MMO Reference: DCO/2022/00007
Planning Inspectorate Reference: EN010125
Identification Number: 20050160

25 April 2025

Planning Act 2008, RWE Renewables UK Dogger Bank South (West) Ltd and RWE Renewables UK Dogger Bank South (East) Ltd Proposed Dogger Bank South Offshore Wind Farms Order

Deadline 4 Summary

| Figure: 10-6e                                            | Drawing No: PB2340-MAR-OF-ZZ-DR-Z-0023 |                                                             |                     |

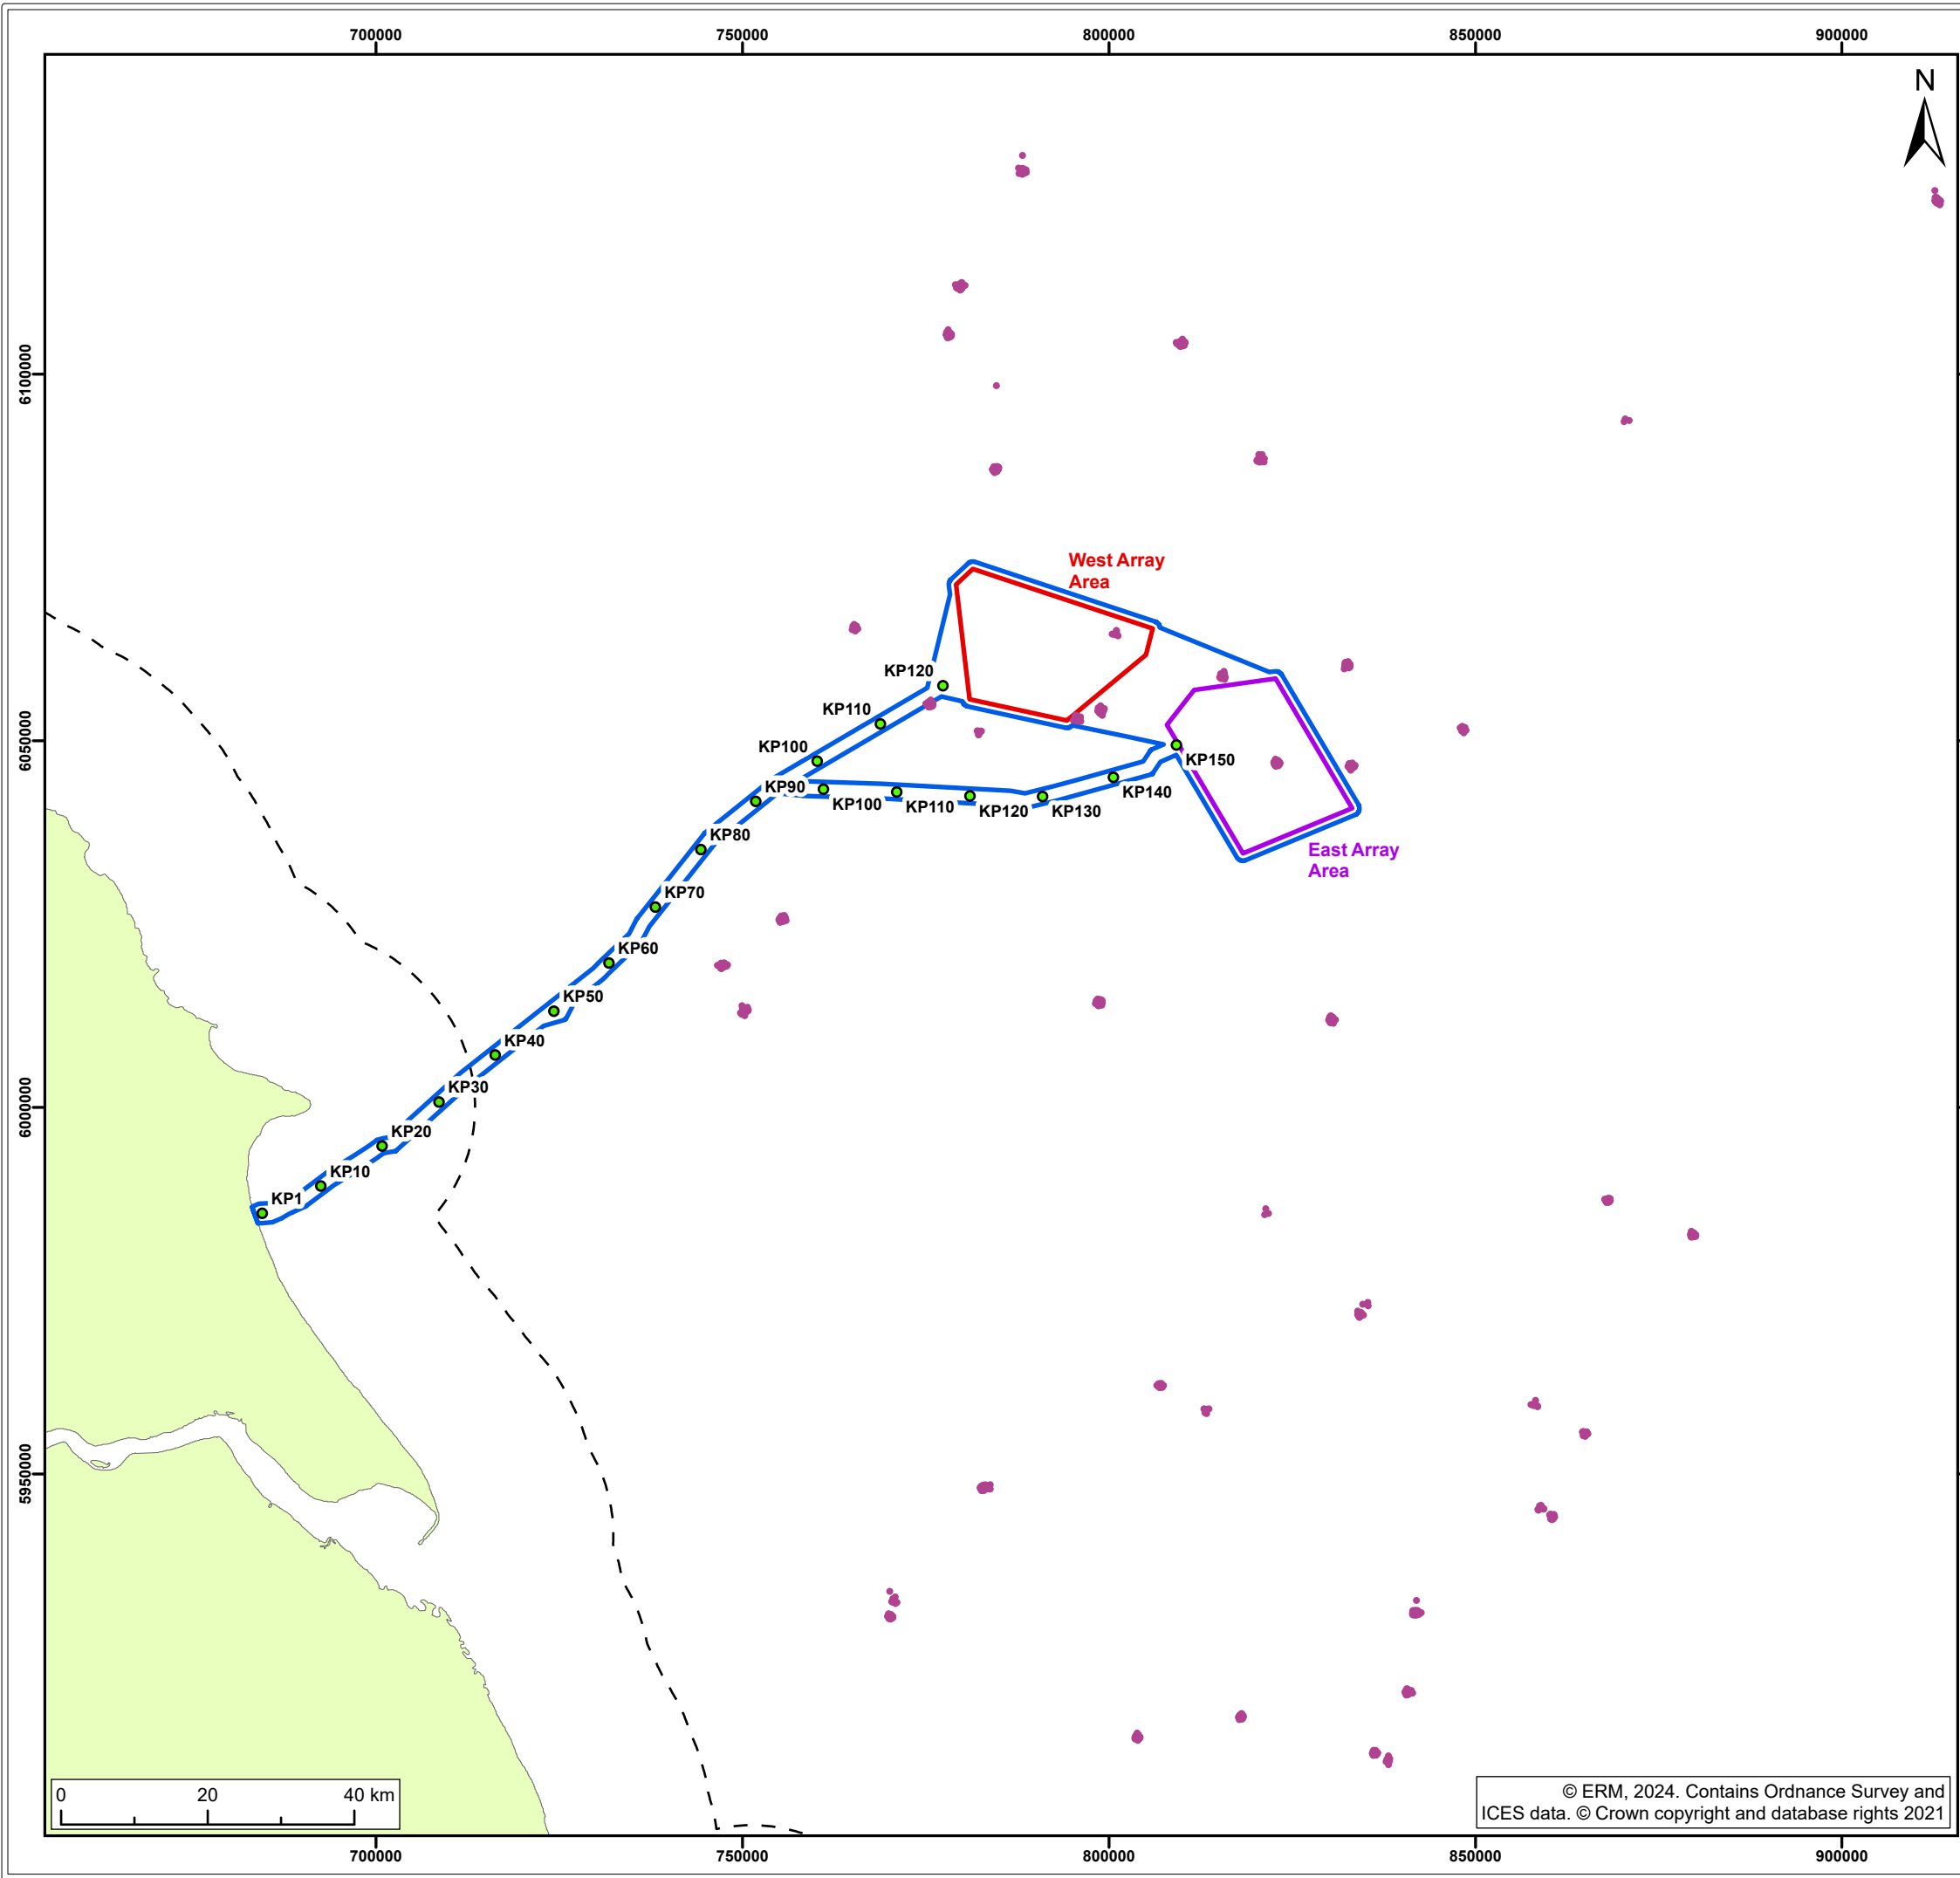
"The Applicant's would like the MMO to clarify whether the >600 larvae per metre squared (m²) category consists of anything other than high abundance that would warrant a change to the figure's legend, and if so, what the updated categories should be; bearing in mind the intention of the display of IHLS abundance data in this report as an indicator of spawning activity".

- 1.7.2 This included a request for further information to be required including reference to Rampion 2 maps.
- 1.7.3 The MMO and our scientific advisors have suggested a meeting to discuss this further and currently arranging this with the Applicant. Any documents or updates that will be discussed should be provided at least two weeks prior to the meeting to ensure the information can be reviewed prior to the meeting.
